HARBOUR CONTROL TOWER

INTERPRETATION PLAN CONSULTATION REPORT

April 2016

Plan of Barangaroo from the *Barangaroo Public Art and Cultural Plan* showing landmarks and areas for interpretation in pink. GML has added potential locations for Harbour Control Tower interpretive elements in green.

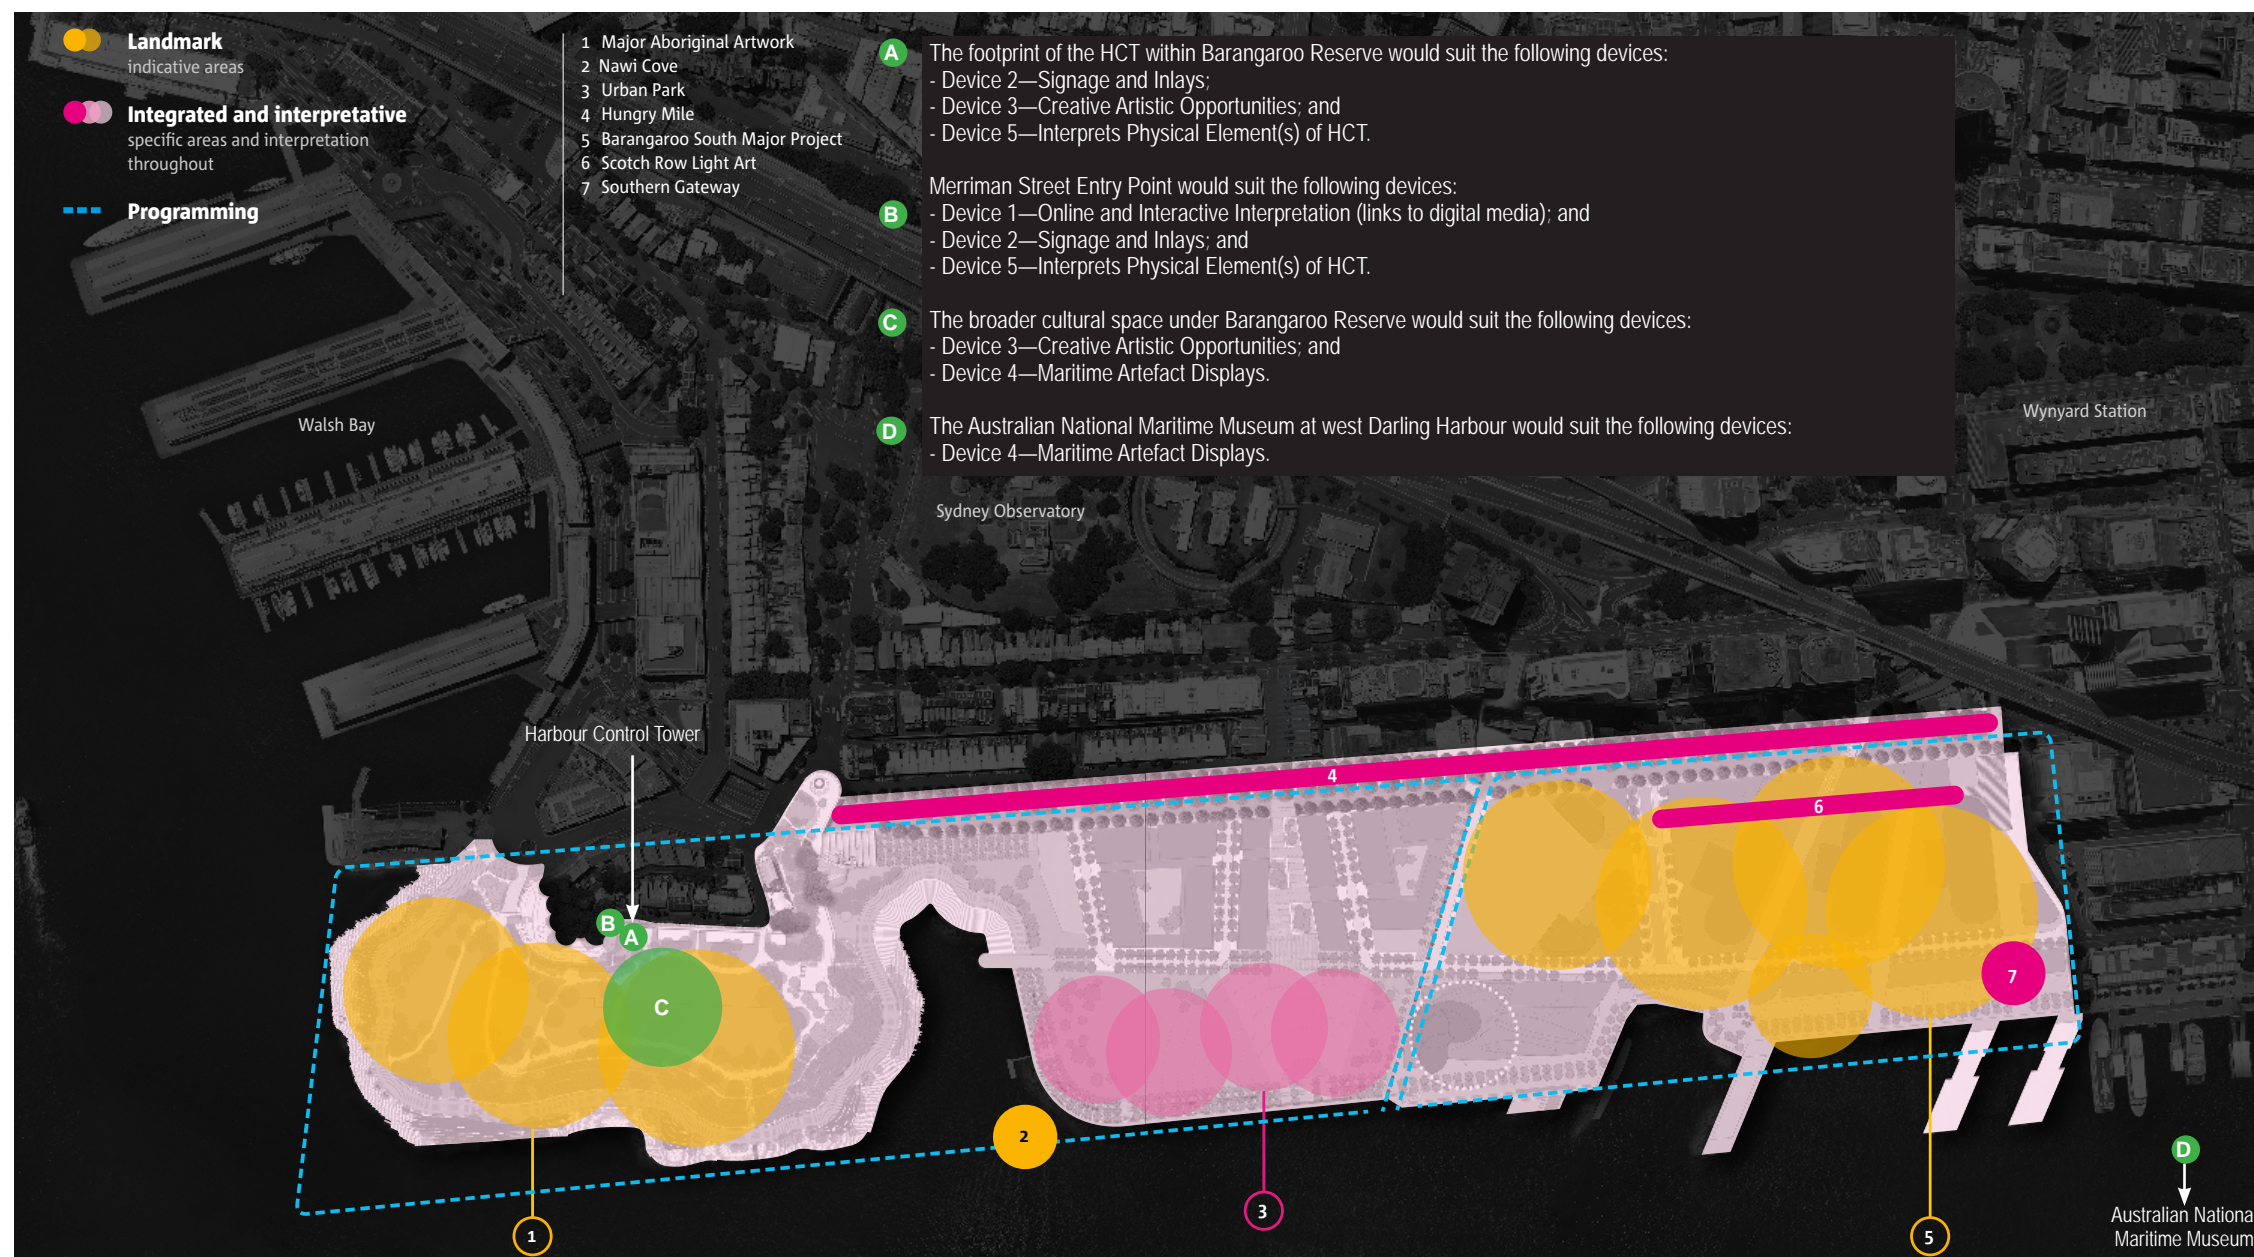
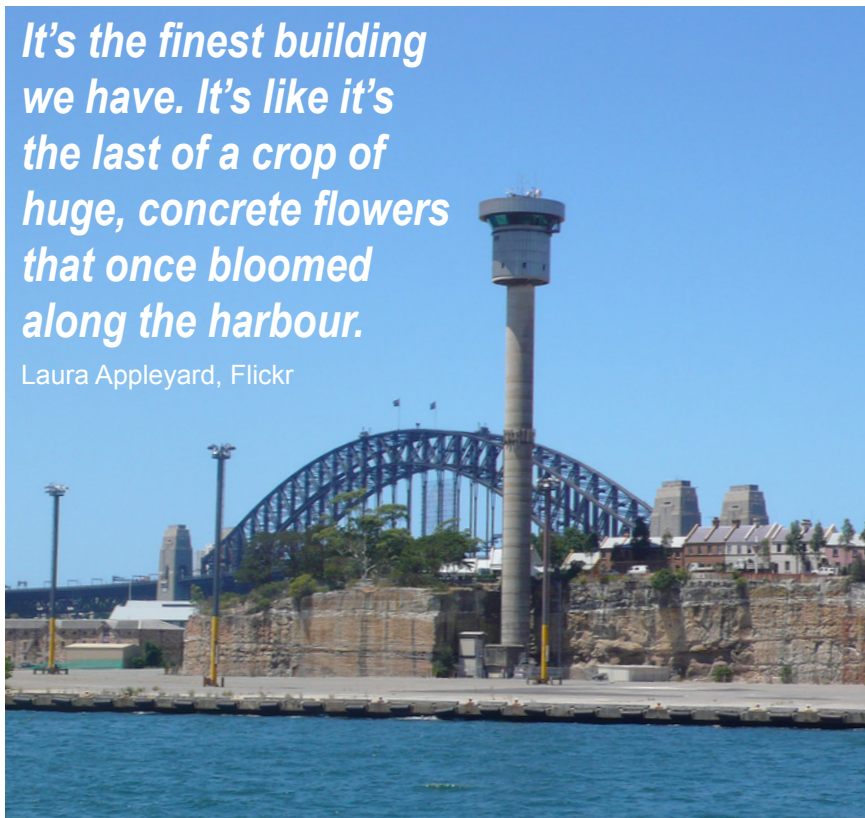
2	4.2	I support the idea of interpreting the HCT as well as the wider history of this area's history as a working port at the current location of the HCT if possible or at the adjacent Merriman Street entry point through the use of a number of elements such as those discussed in the draft Plan and shown on the Plan in section 4.2.	Noted by the Authority.
